CONSULTEE RESPONSE (Council's Arboriculturist)

Reference: BN/65/22/PL

Proposal: Sever land and erection of 1 No bungalow with new vehicular access (resubmission of BN/14/22/PL). This application is a Departure from the Development Plan and is in CIL Zone 3 and is CIL Liable as new dwelling

Location: Land at rear of Cedar End, Eastergate Lane, Eastergate, PO20 3SJ

Proposed Site Plan
1:200

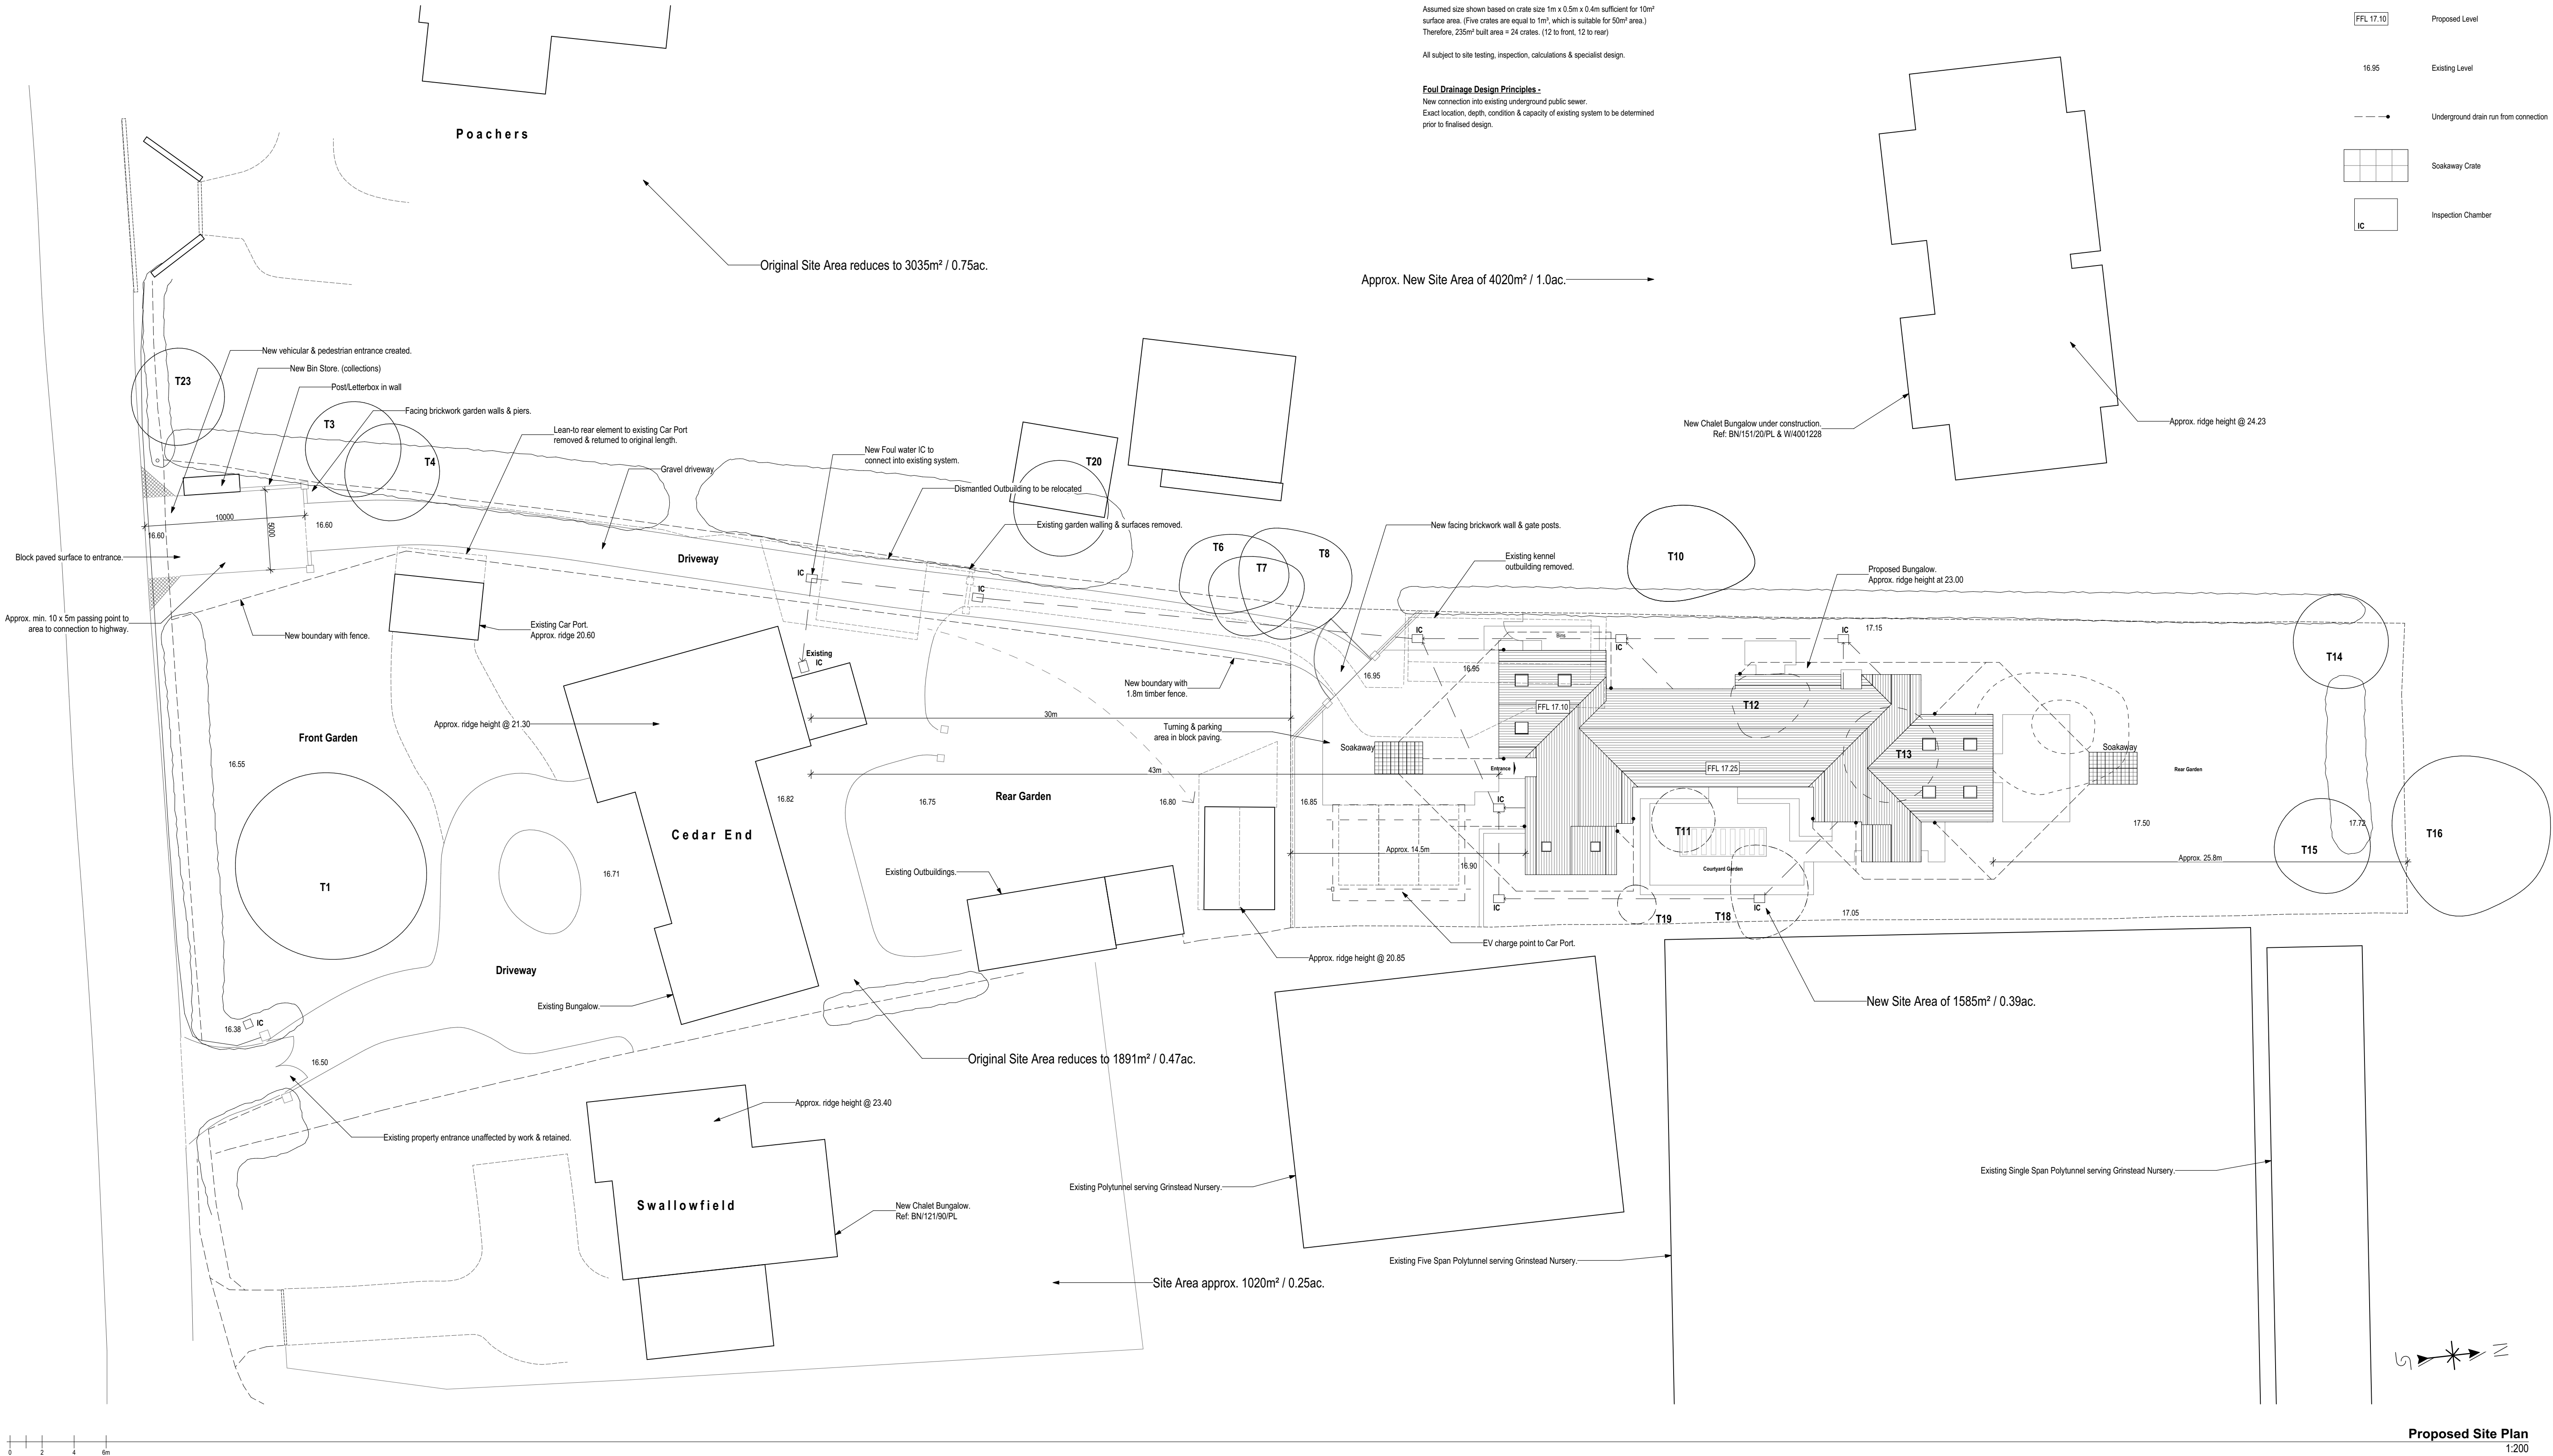
There does not appear to be a surface water drainage (and foul water sewer) strategy for the site. **Addressed.**

I draw attention to the nominal root protection areas (RPA) of retained trees and their growth potential as obvious constraints to the siting of any SUDS feature, soakaway or introduction of subterranean utility apparatus.

Drainage and service-runs in and out of site have not been shown and so there remains a risk of root protection area incursion to satisfy those requirements.

Foul and Surface water drainage features are shown located outside of and appropriate distance from retained trees. Dwg. no. 1671-SYM-00-ZZ-DR-A-0207 P04, Symmetry Architecture.

MAP REFERENCE : TPP.CE.0767.V1
SITE: Cedar End, Eastergate Lane

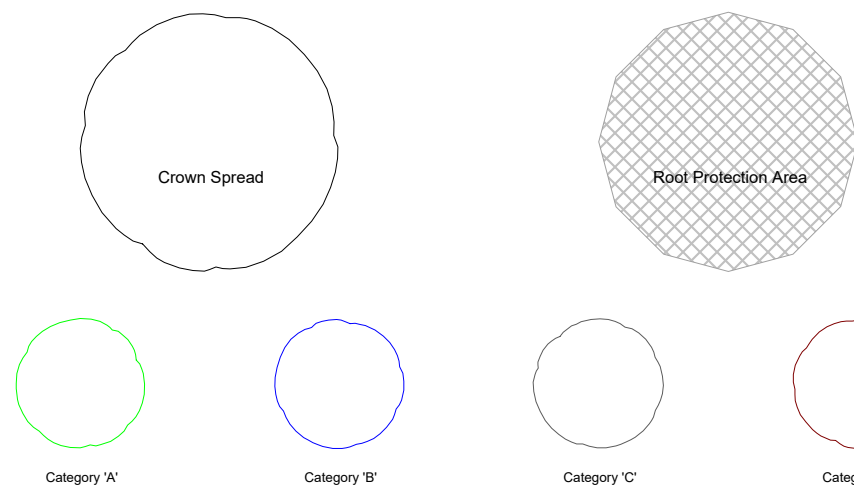
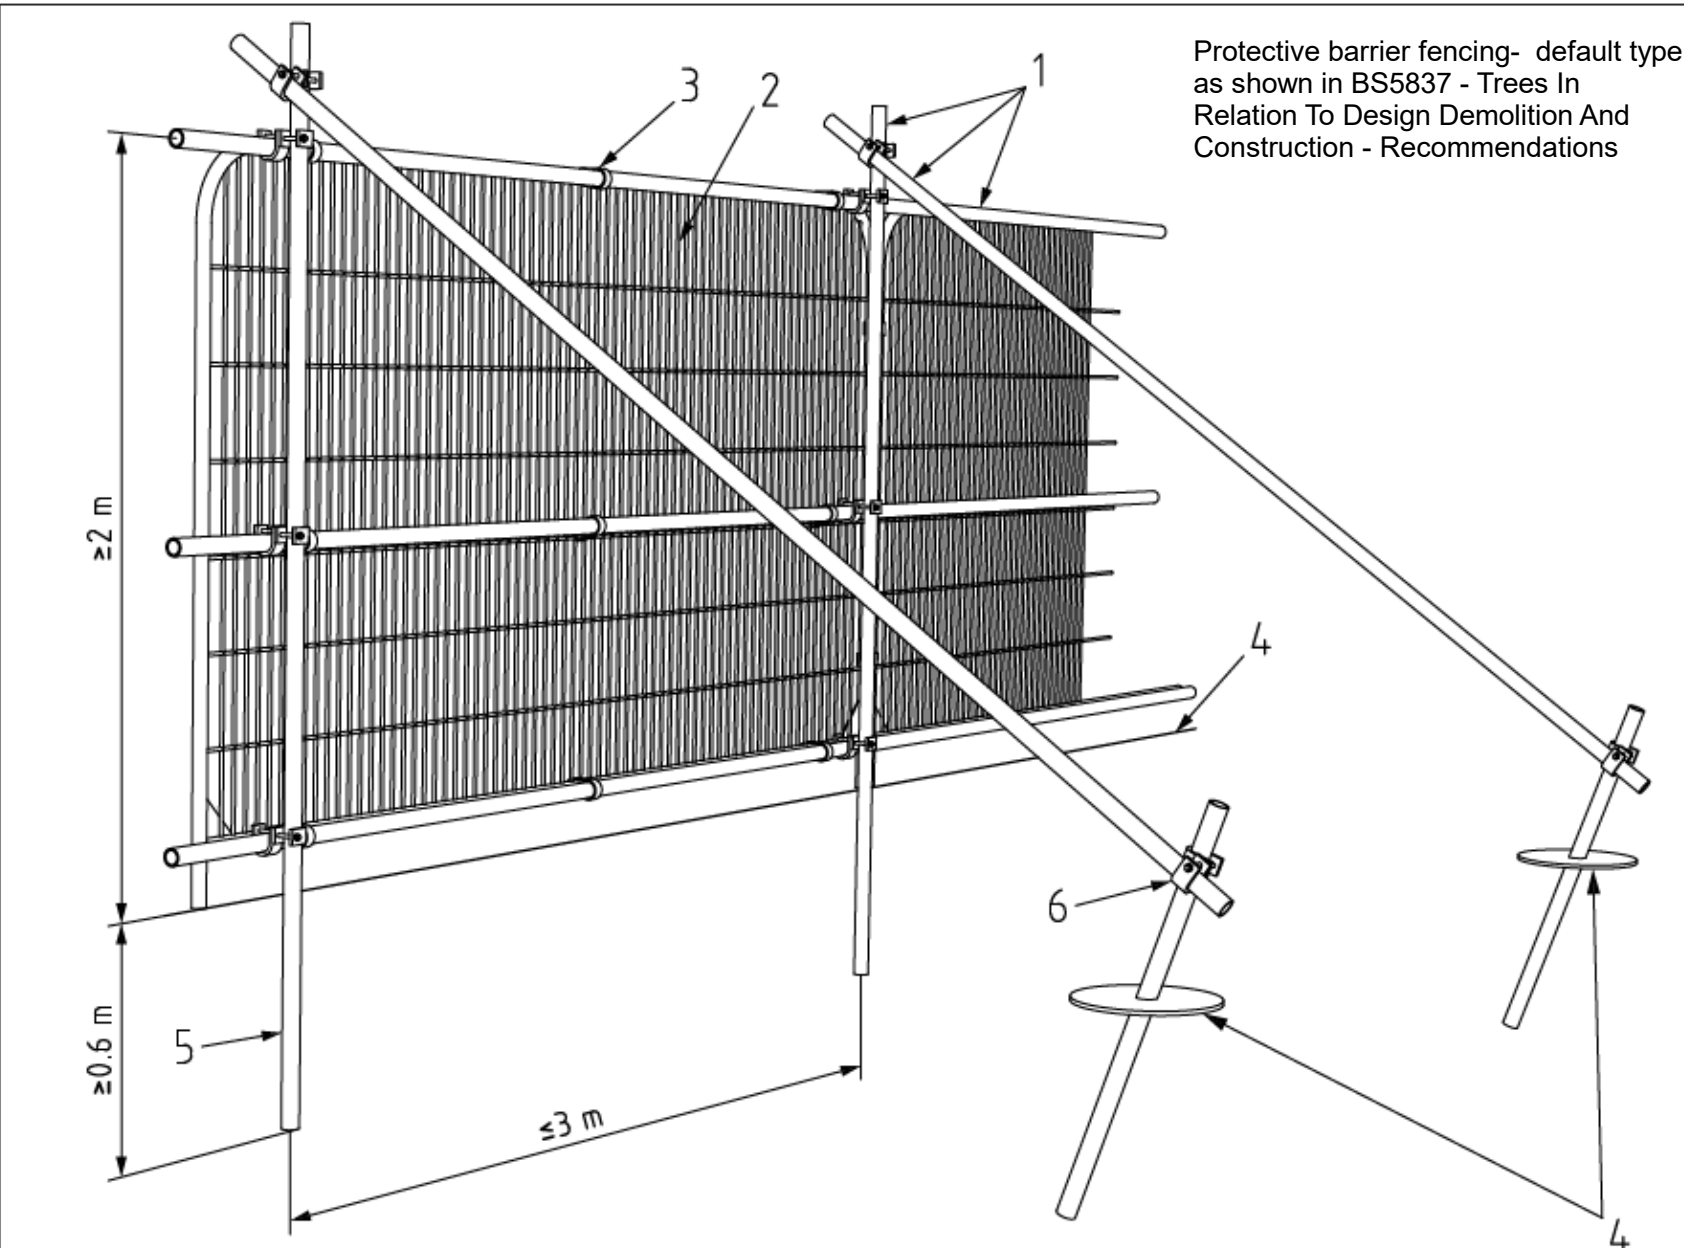
No Arboricultural Method Statement or Tree Protection Plan has been submitted for this project, despite construction work proposed within the root protection area (RPA) of retained trees. **Resolved.**

If an RPA of any tree which is proposed for retention overlaps the development, then BS5837:2012 requires that the Detailed Planning Application is accompanied by an Arboricultural Method Statement (AMS) and most importantly a Tree Protection Plan – to both describe and illustrate the mitigation measures which are to be employed to ensure the trees survive without detriment to their vigour and vitality and are given adequate protection both above and below ground.

-Type and methodology for engineered solution to driveway construction within the RPA of off-site trees. **Resolved.**

The applicants have employed The Arboricultural Consultancy Ltd. to prepare an Arboricultural Method Statement along with a Tree Protection Plan for this project.

- I) Tree protective fencing has been inspected and found to be 'Fit for Purpose' as required under British Standard 5837:2012 and been erected and positioned exactly as shown on the Tree Protection Plan, dwg no. TPP.CE.0767.V1, 28/07/2022**
- II) Installation of 'No-dig' construction for driveway across RPAs has been completed under arboricultural supervision, utilising a cellular confinement system and finished with a temporary hard wearing course – all as described in the approved AMS and to act as ground protection throughout the construction phase of development.**
